Your Ref: OWPC26492
Our Ref: EP/37/20/HH 24-03-2020
Please ask for:
Zac Denton

Single storey side/rear extension, part two storey rear extension rear extension, raising of roof height to create a second floor and front double garage.

56 Angmering Lane East Preston Littlehampton

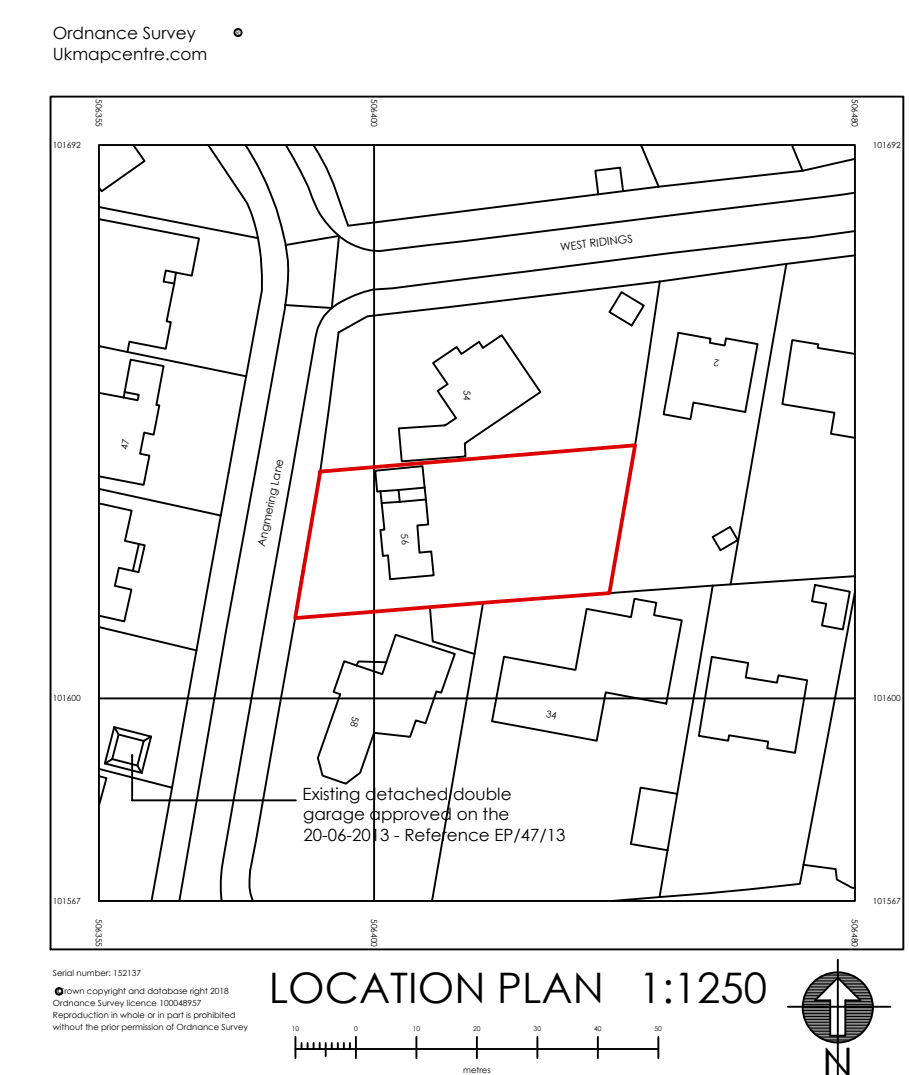
- the addition of another floor is completely out of keeping with all the other houses in the area and will spoil the character and quality of the estate.*
- There are no houses on the estate with 3 floors and it would set a precedent.*
- The proposed garage is in front of the building line and will have an adverse visual impact on the street scene.*
